Our reference: ECM Ref: 9567506  
Contact: Gavin Cherry  
Telephone: (02) 4732 8125

13 May 2021

**Response to Request for Advice: SSD-9522 Mod 1 – Modification  
Application and Report for the Kemps Creek Warehouse, Logistics and  
Industrial Facilities Hub at Nos. 657 – 769 Mamre Road Kemps Creek**

Figure 1a: Lot 8 Site Plan

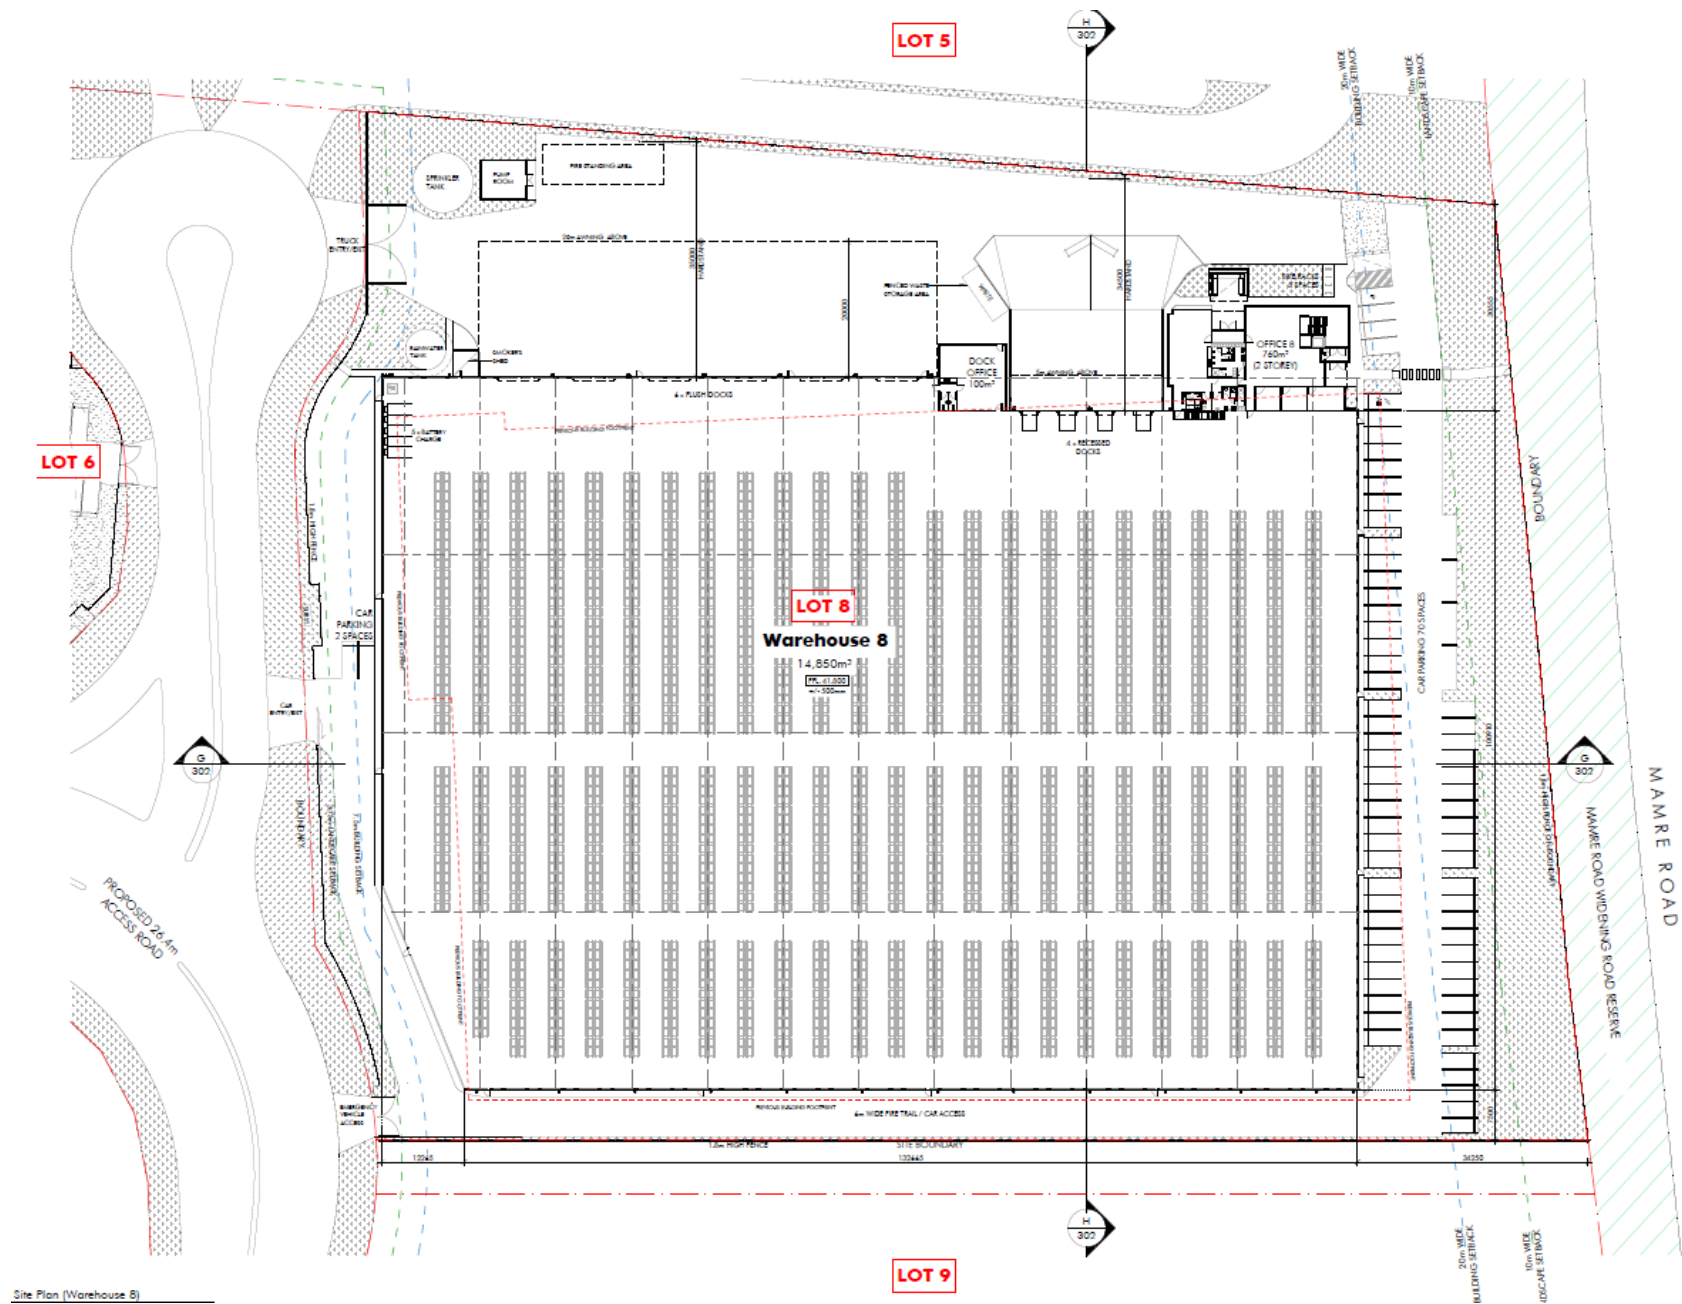
- The proposed setback of Warehouse Lot 8 car parking / hard stand to the rear internal road is only 3.75m which is unacceptable, contrary to the previous approval and must be amended to reinstate the required and approved 4.0m setback between car parking and the property boundary.
